SUBMISSIONS REPORT

SSDA-8865 Mod 1
St Anthony of Padua Catholic
College

Prepared for
SYDNEY CATHOLIC SCHOOLS
3 August 2021

Project Number

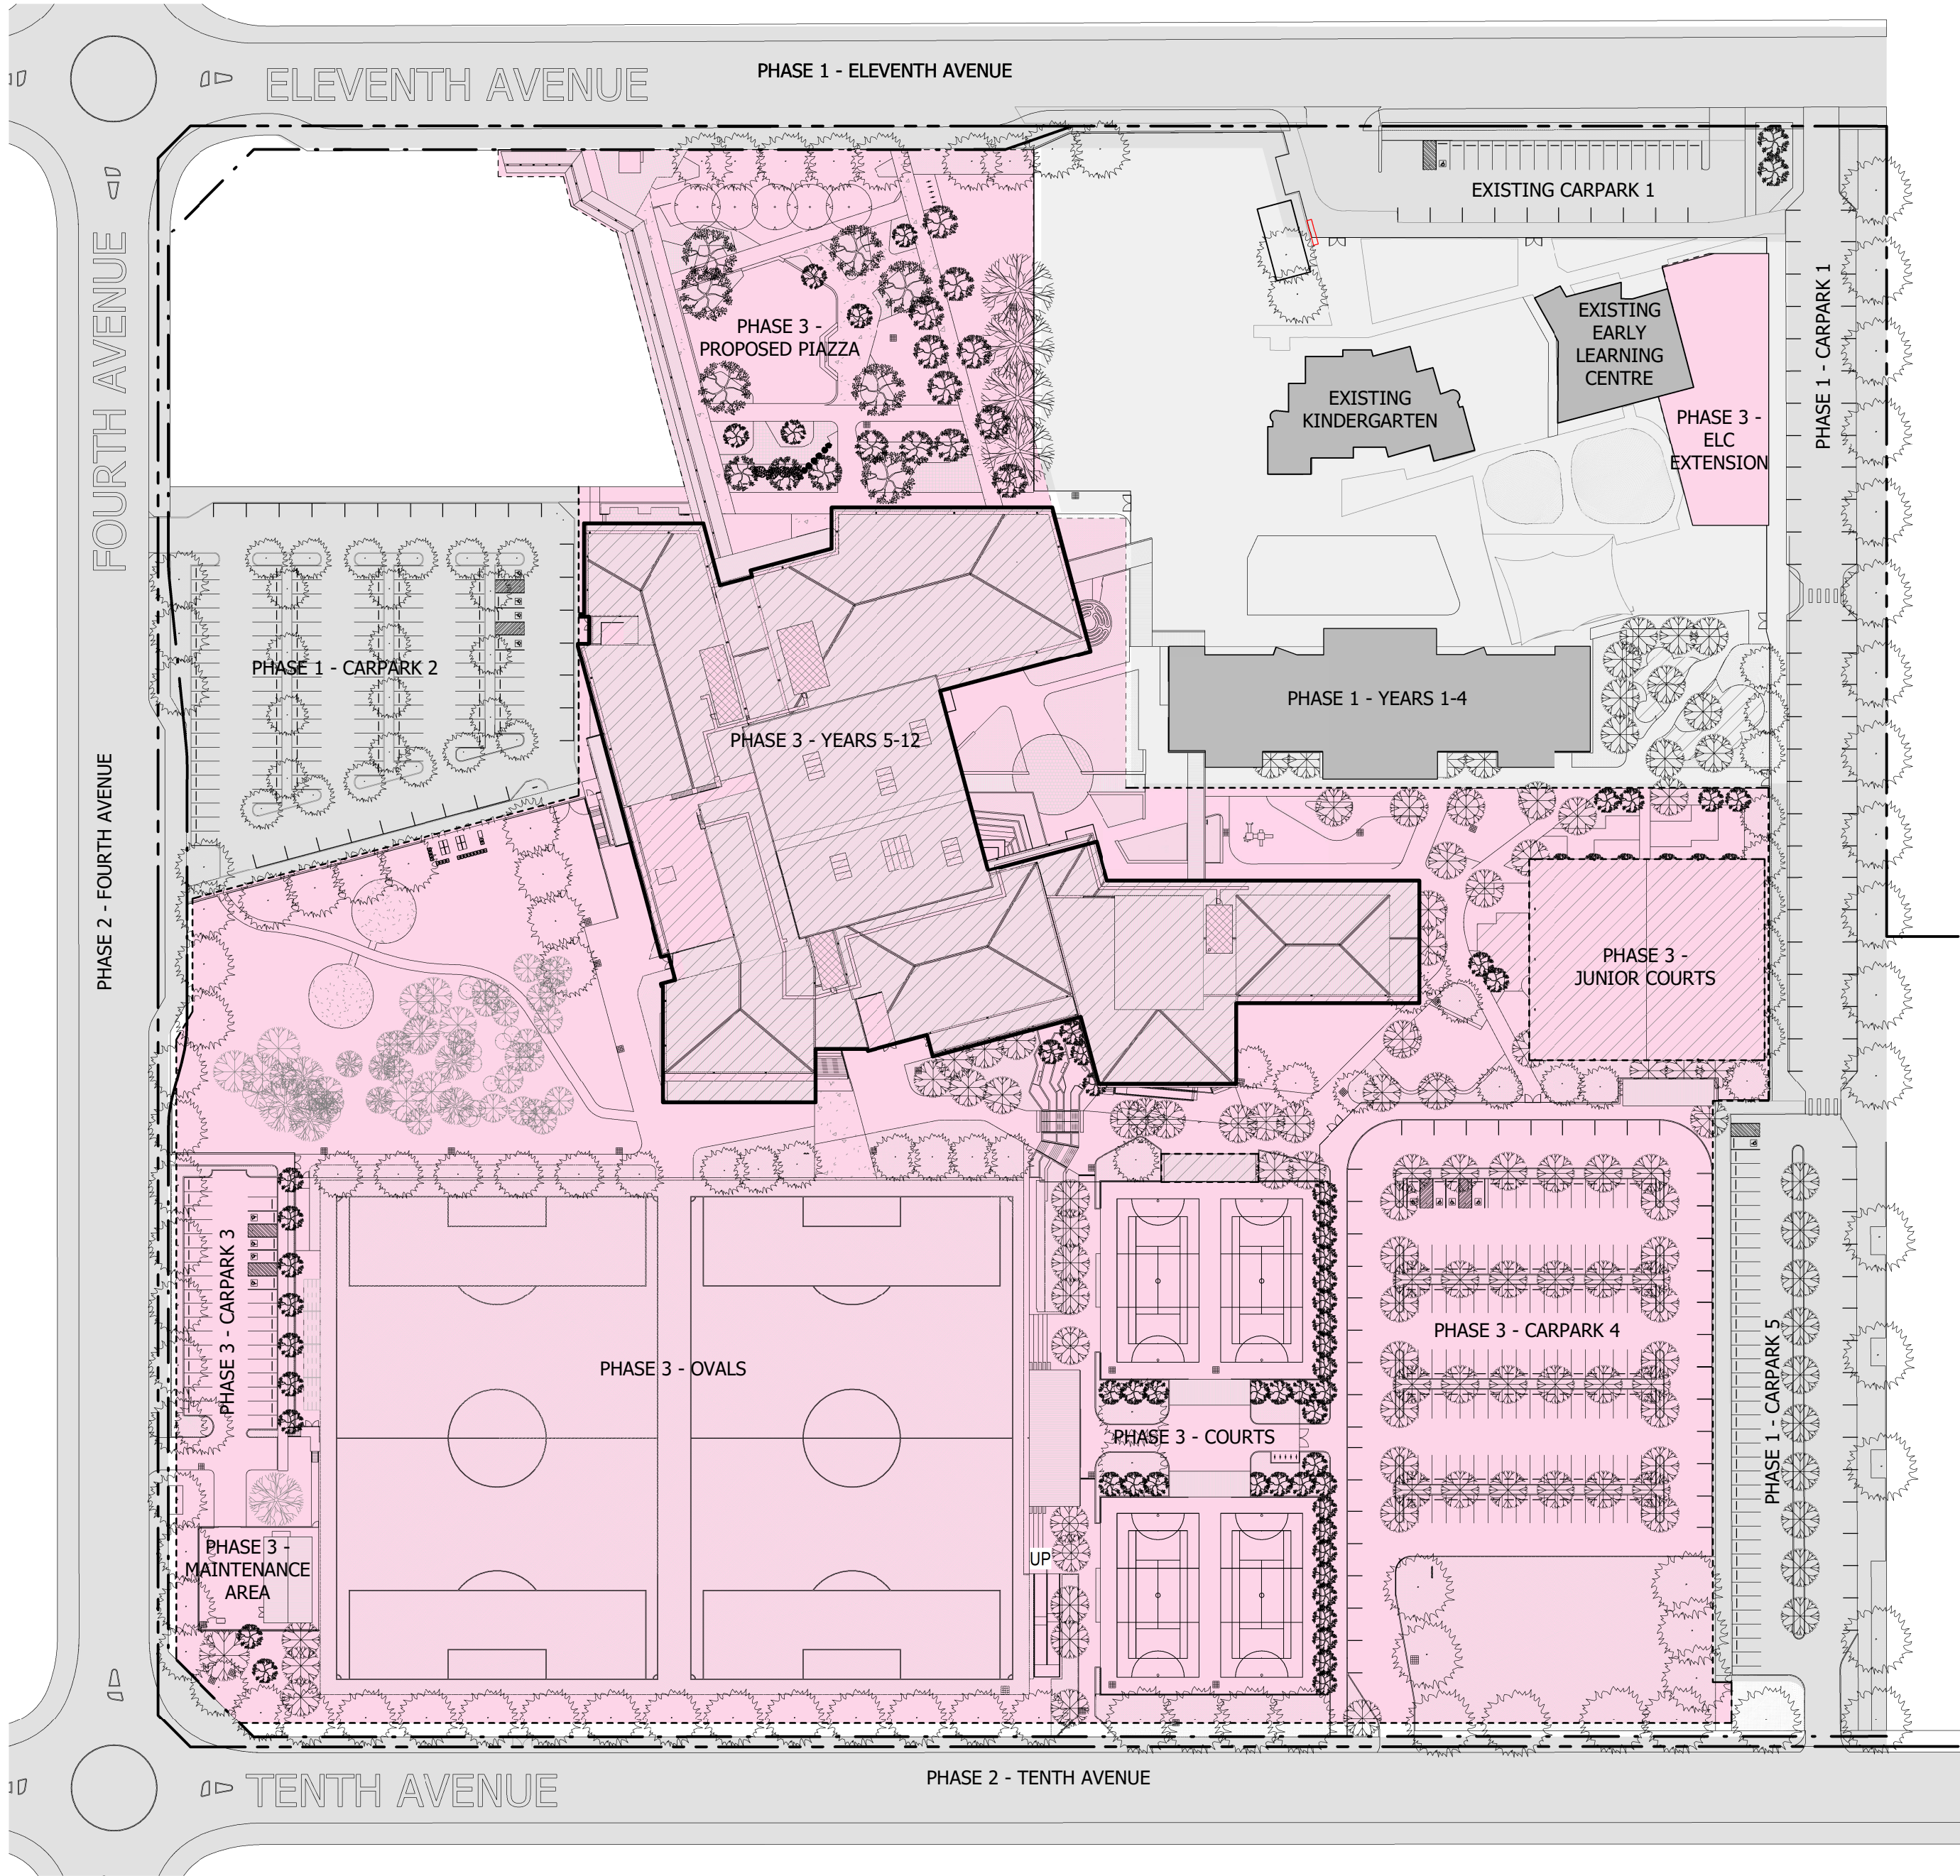
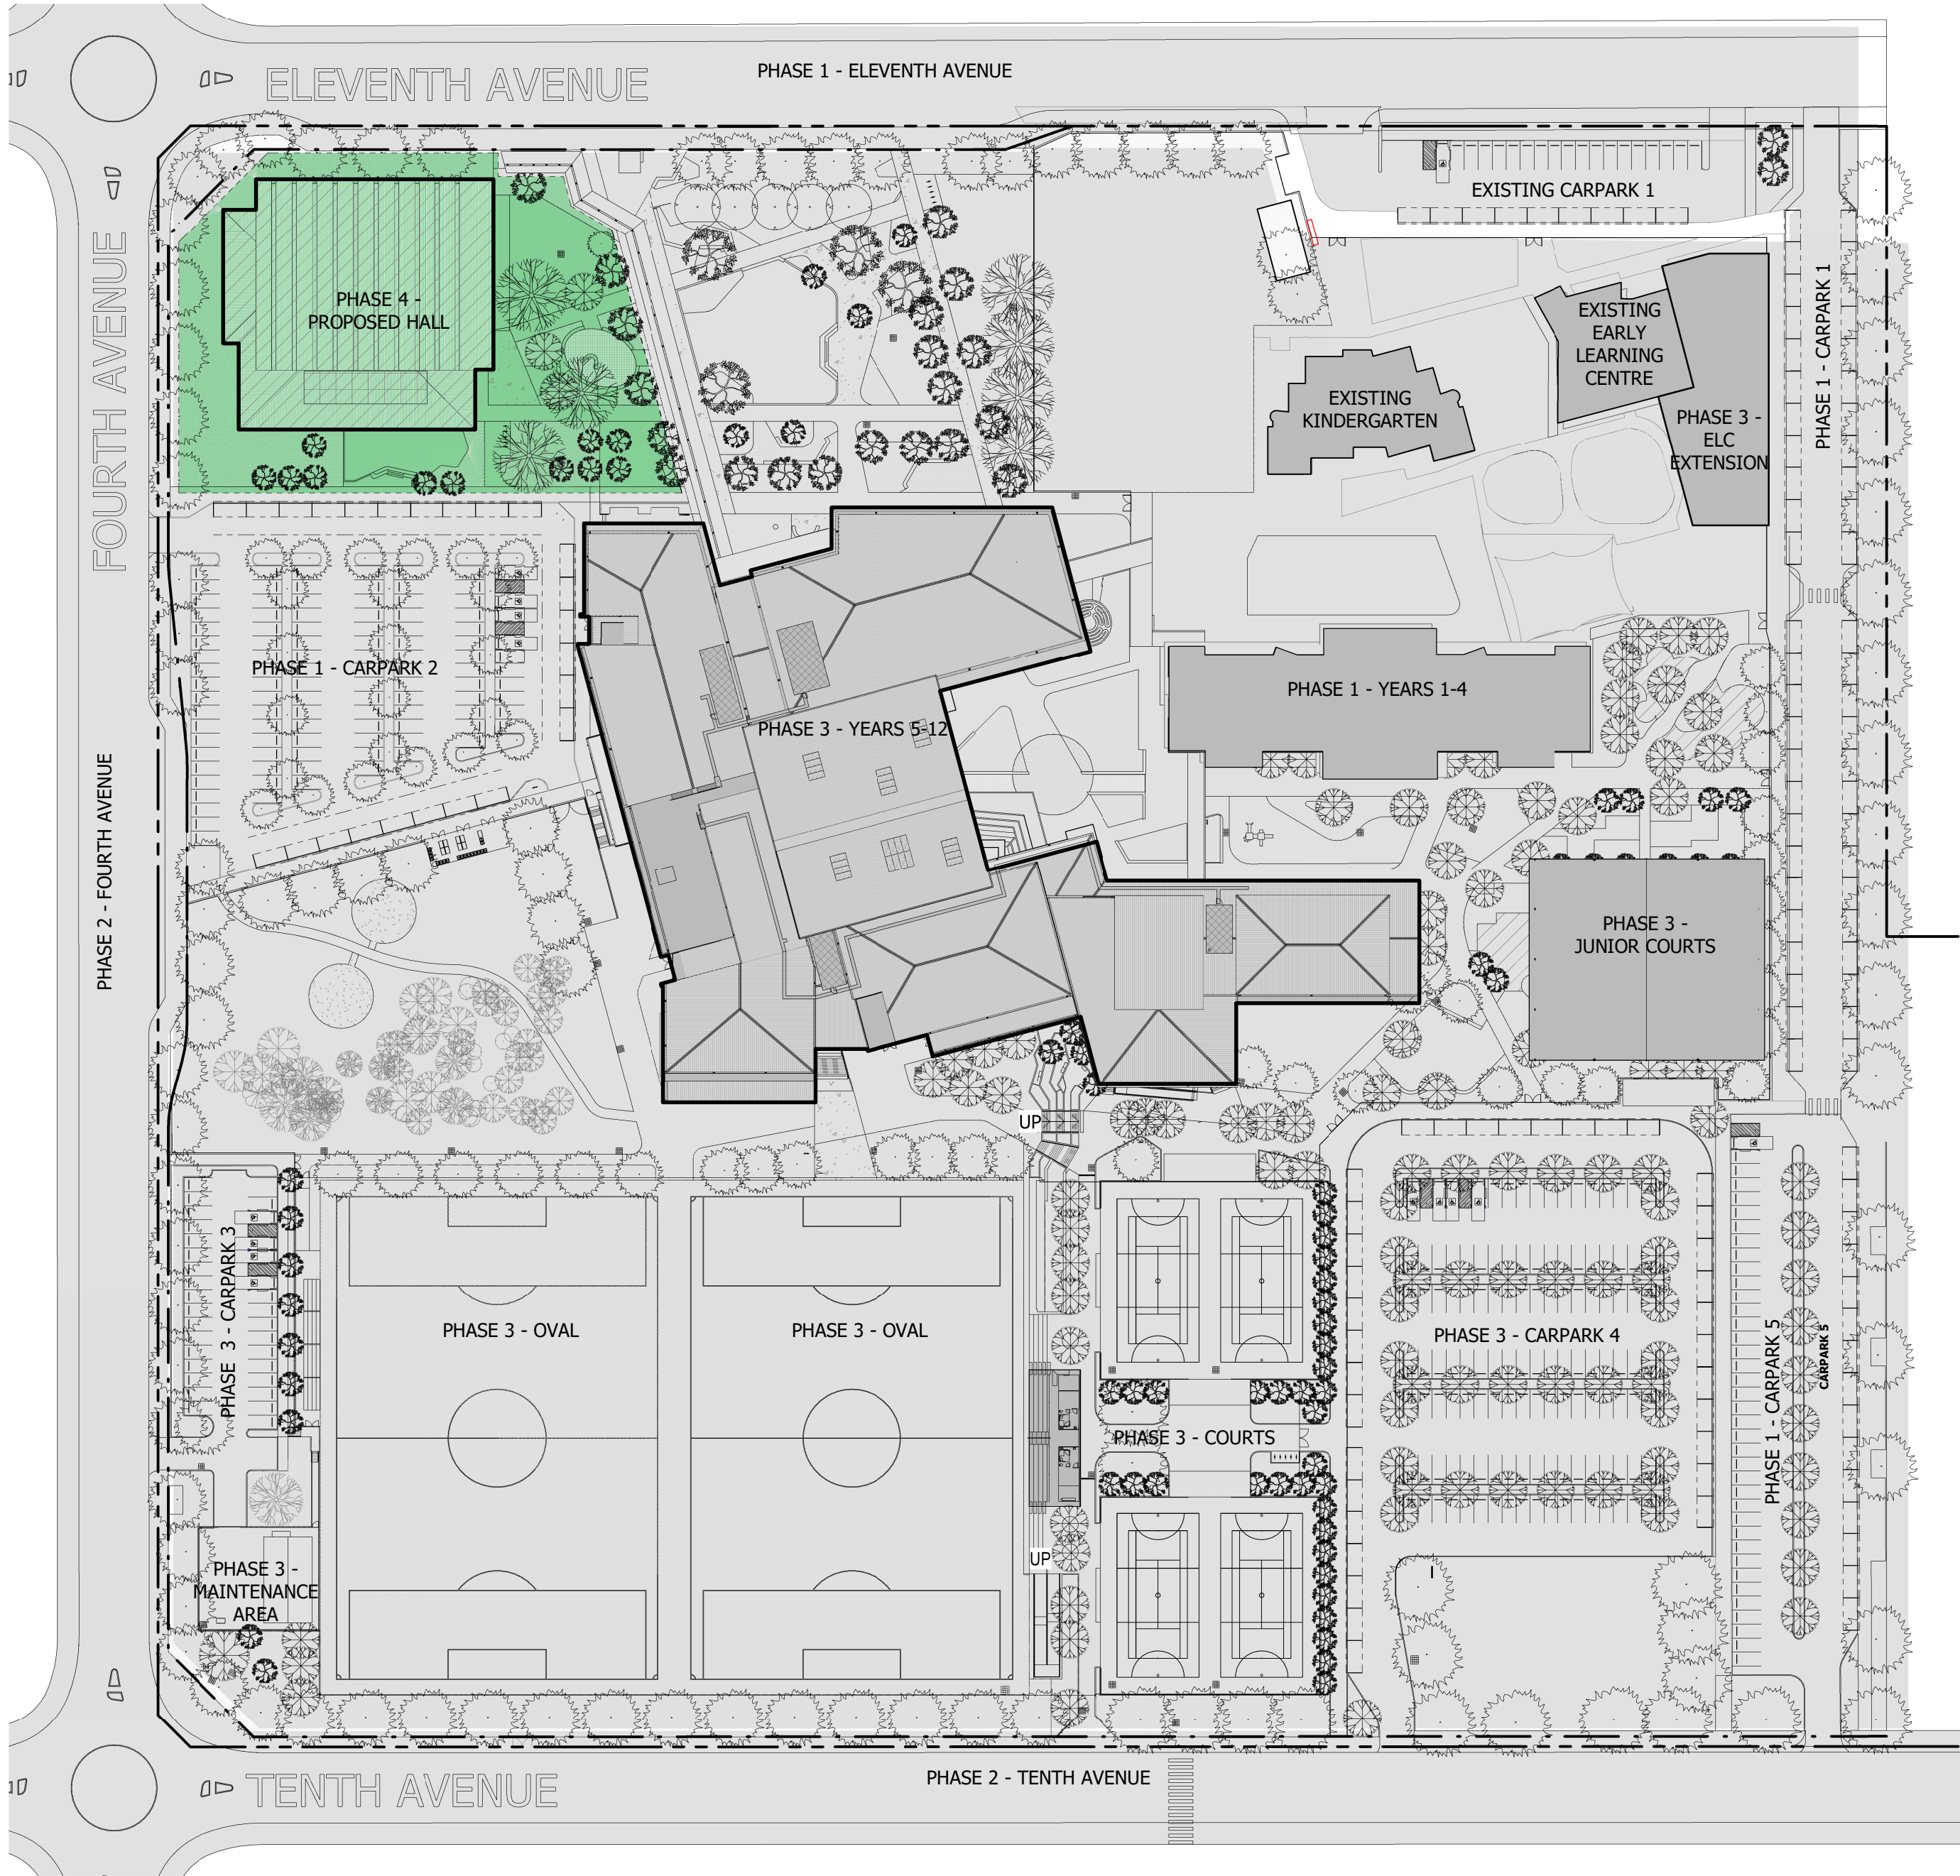
3.	- why the Year 1-4 building, as depicted in the proposed staging plan, is shaded in grey	This error has been corrected in the updated plan set. The Years 1-4 building is part of Stage 1 and is shaded orange. Refer to amended plans at Appendix A.
